Our Ref: AB/73/18/PL

**Town & Country Planning Act 1990 (as amended)
Town and Country Planning (Development Management Procedure) (England) Order 2015
Application for Planning Permission**

Development	Demolition of garage & erection of two dwellings with associated car parking and landscaping
Location	18 Queens Lane Arundel

GROUND FLOOR PLAN - PROPOSED
SCALE 1:100

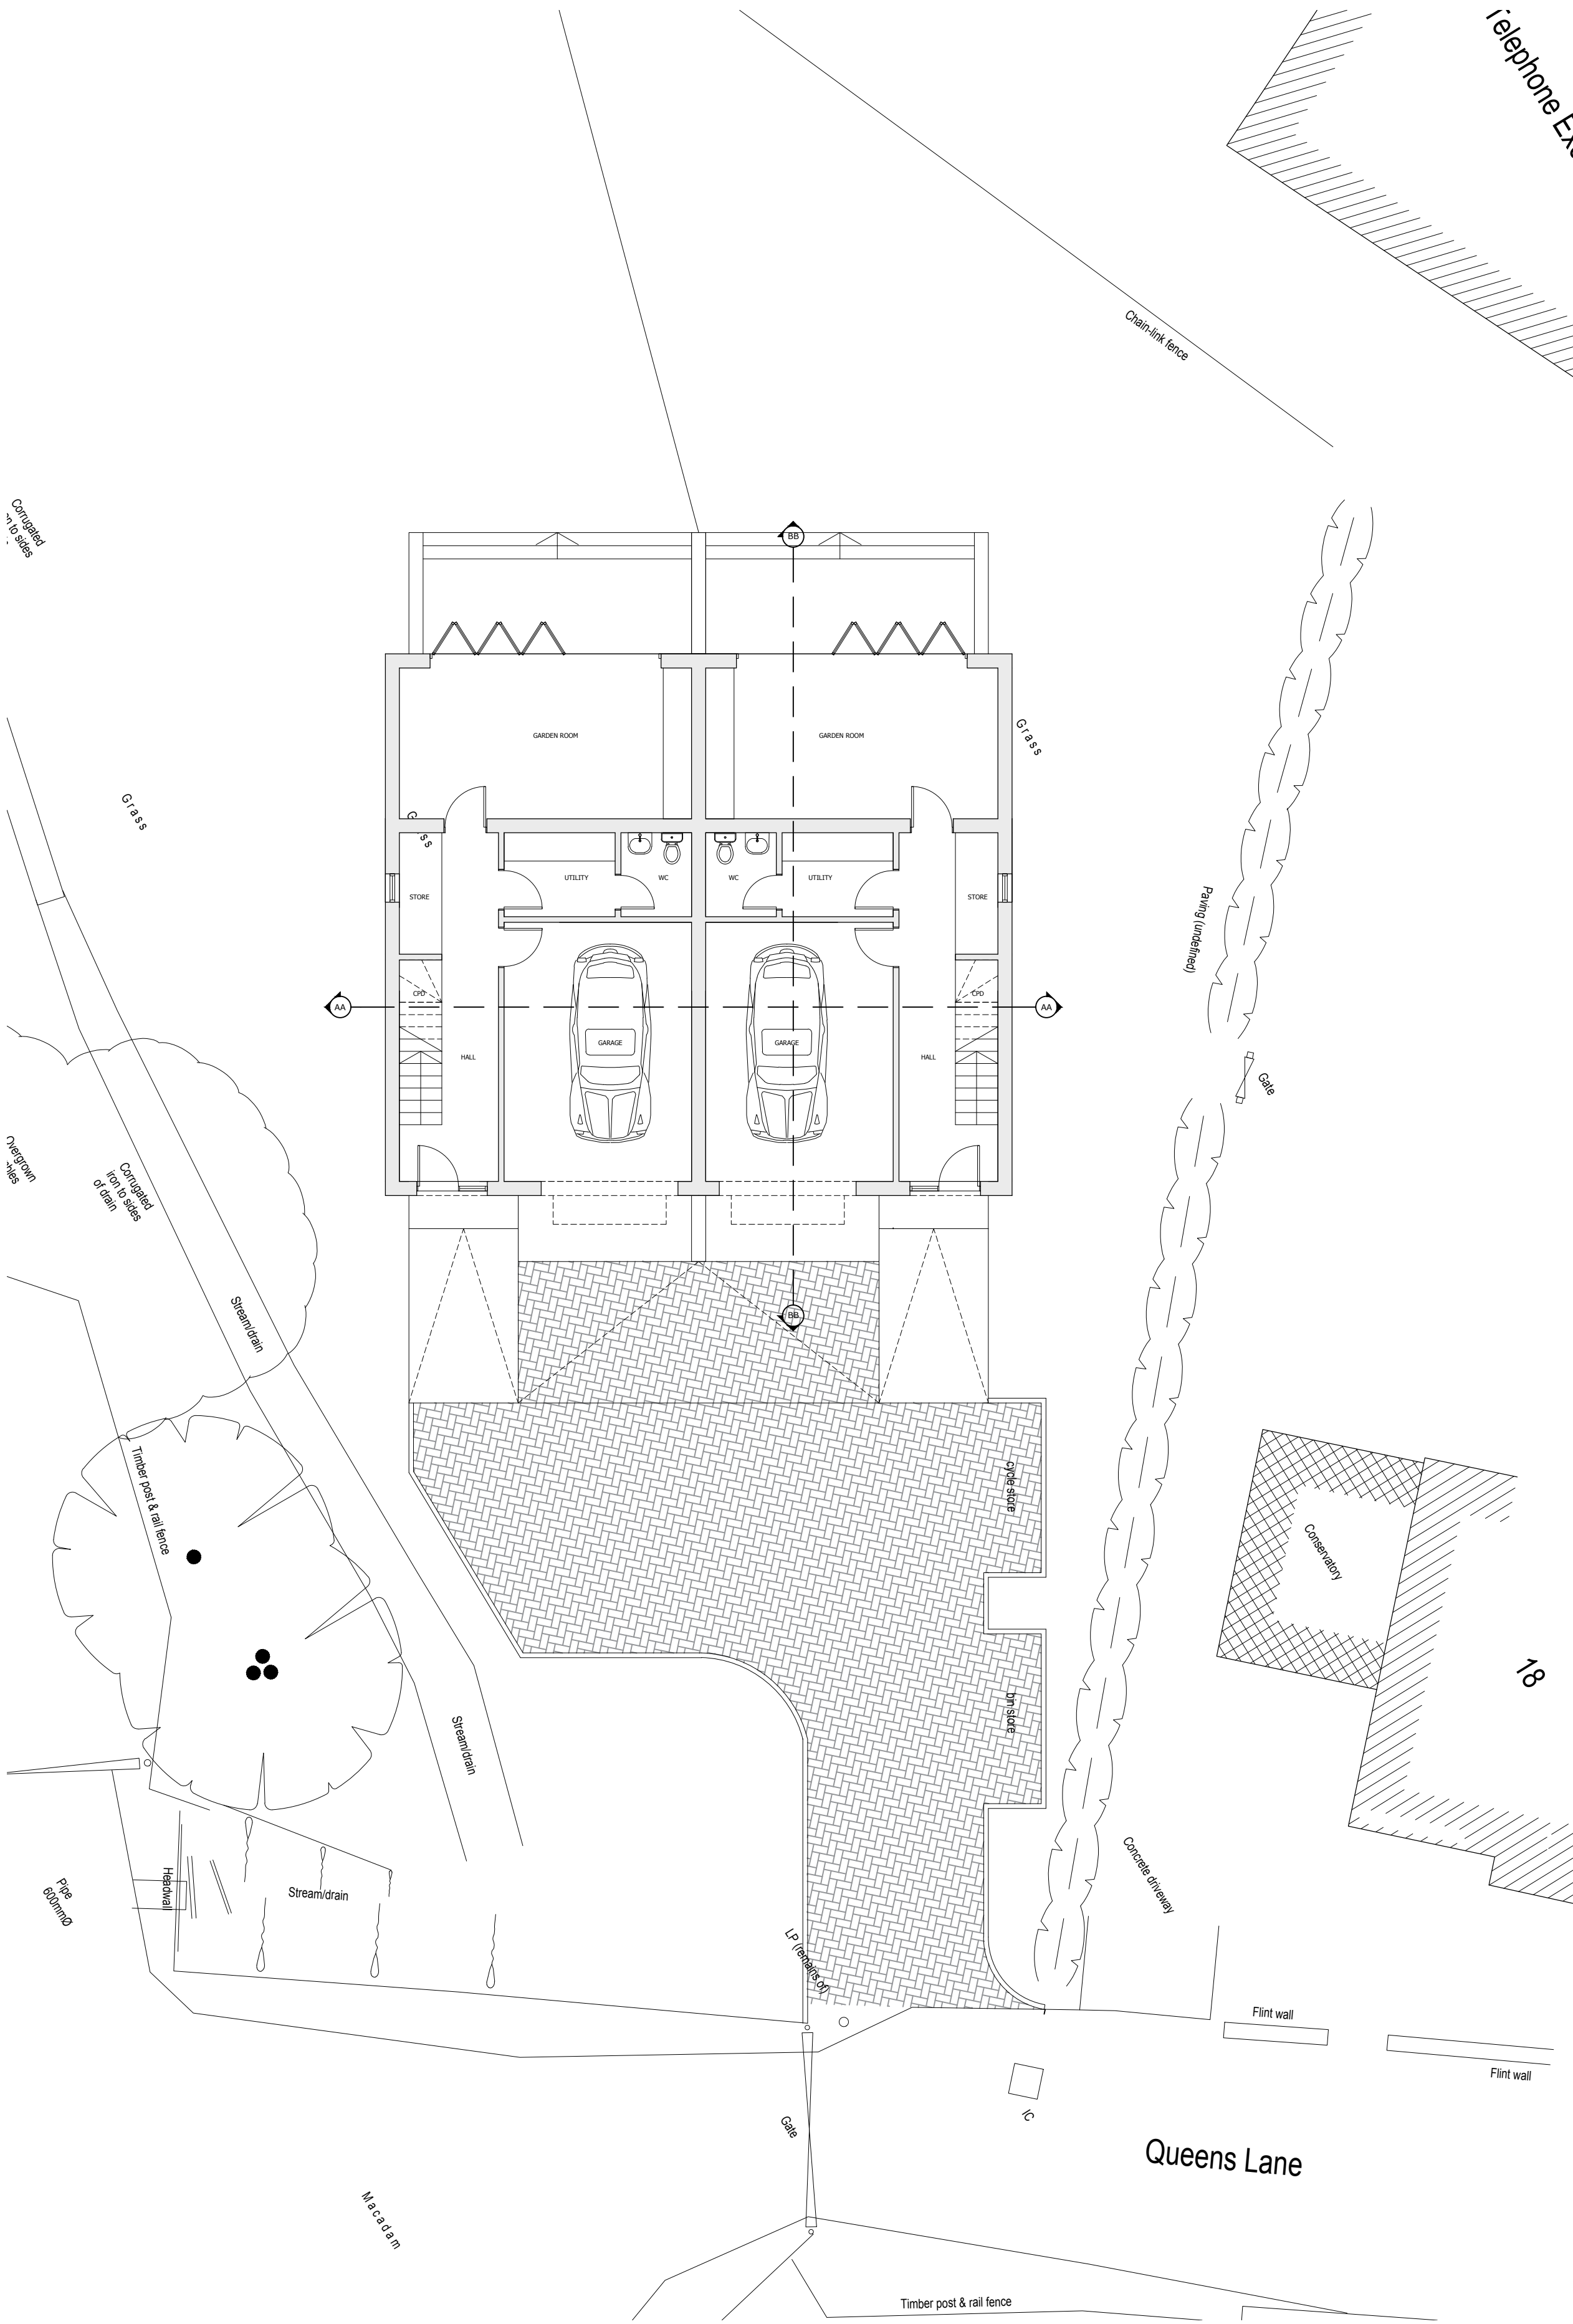
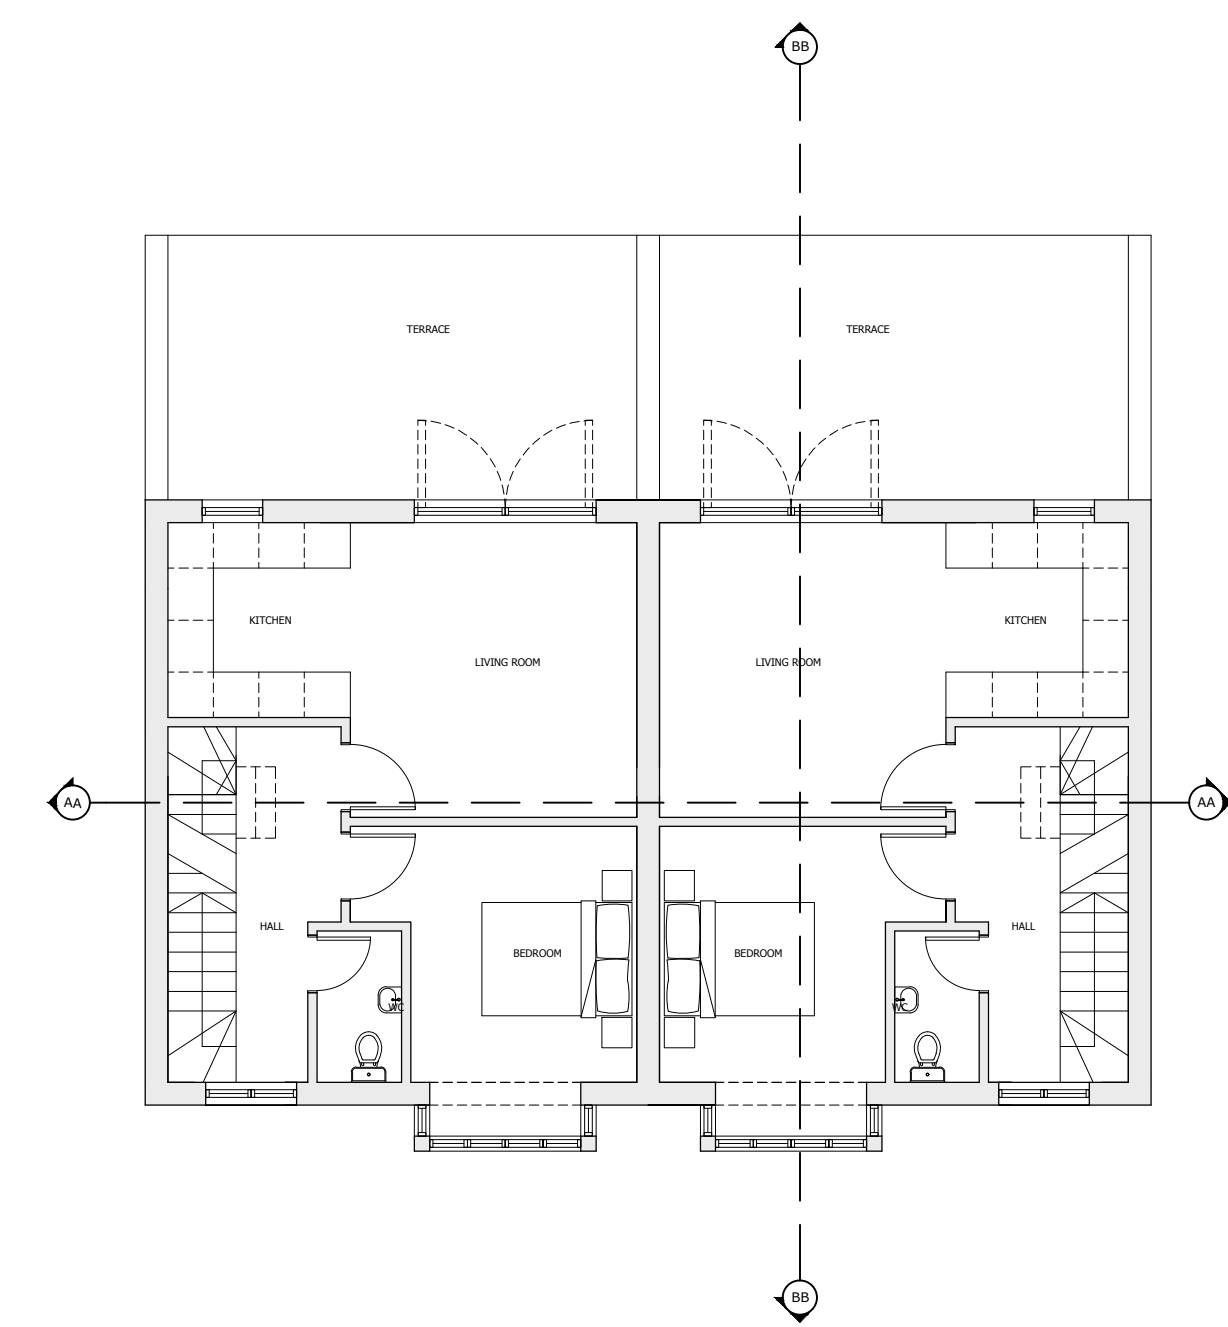
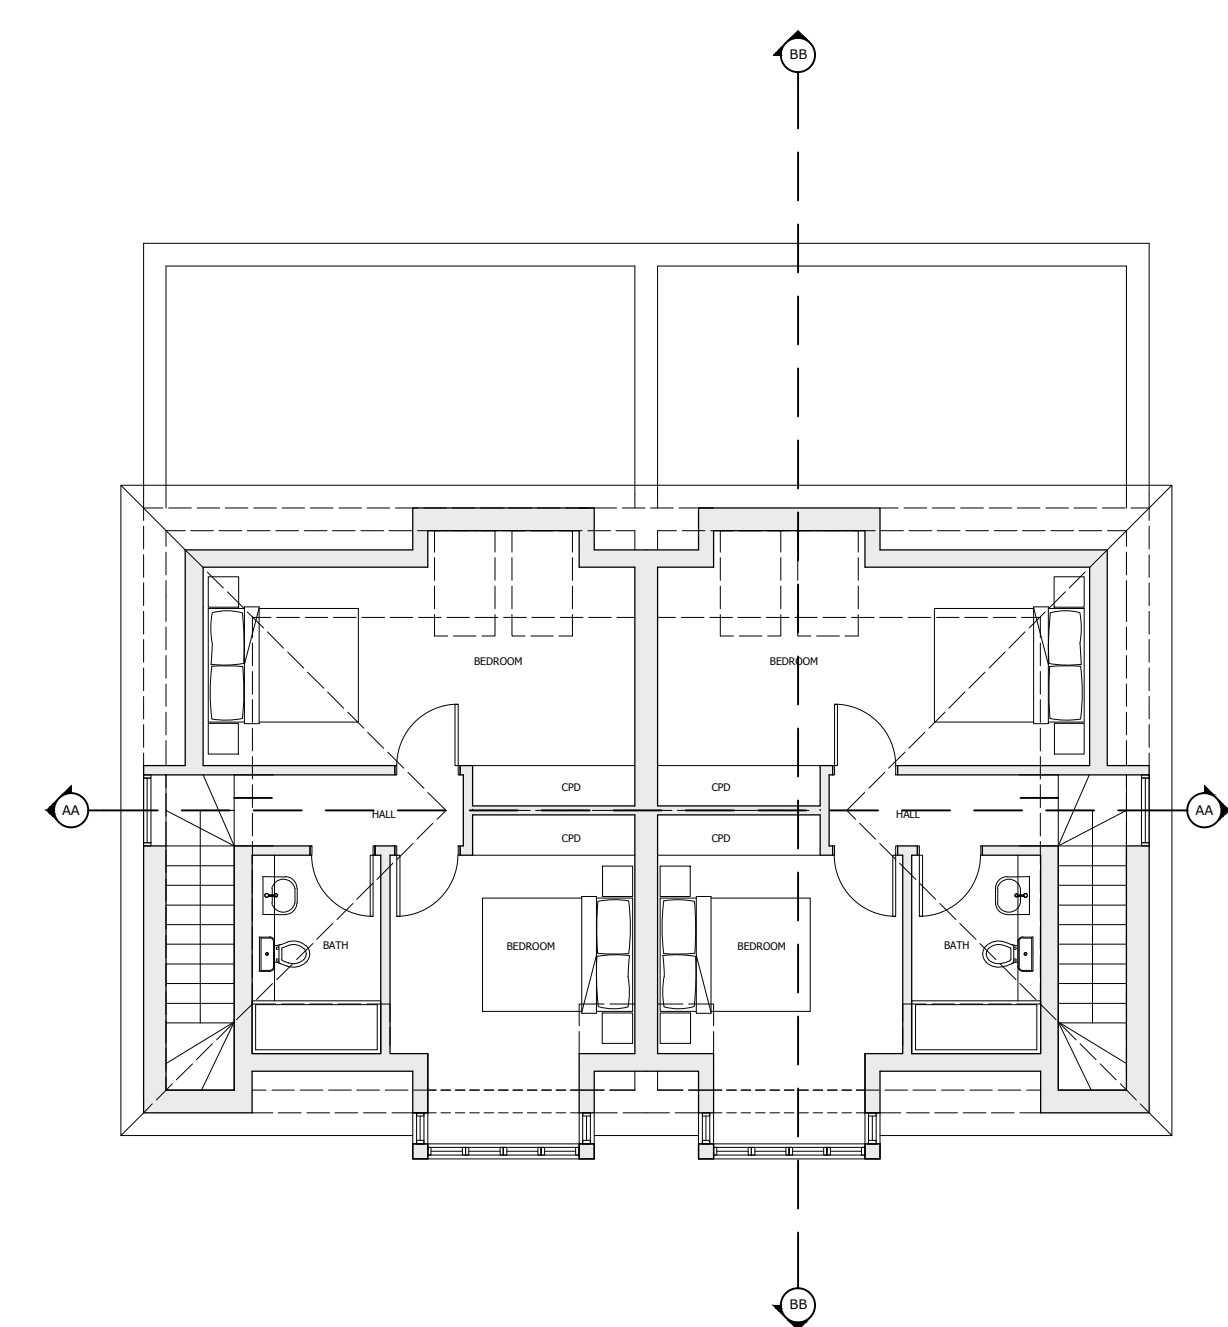
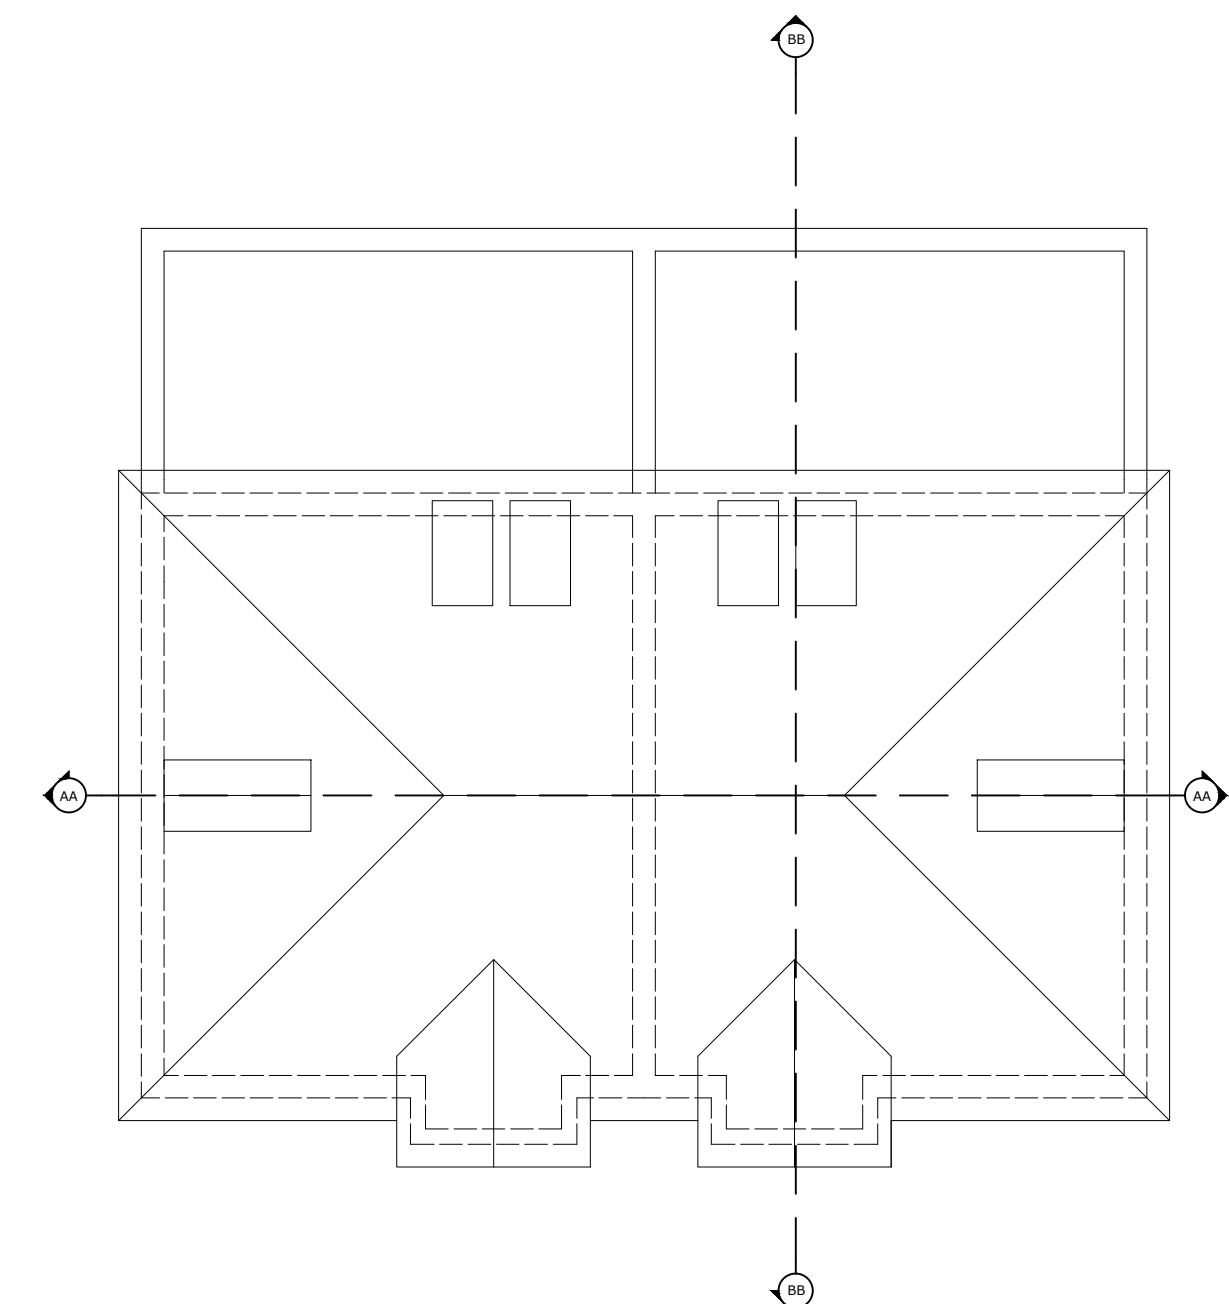
There are small windows indicated on the Proposed North and South elevation that have not been indicated on the proposed floor plans. Please amend accordingly.
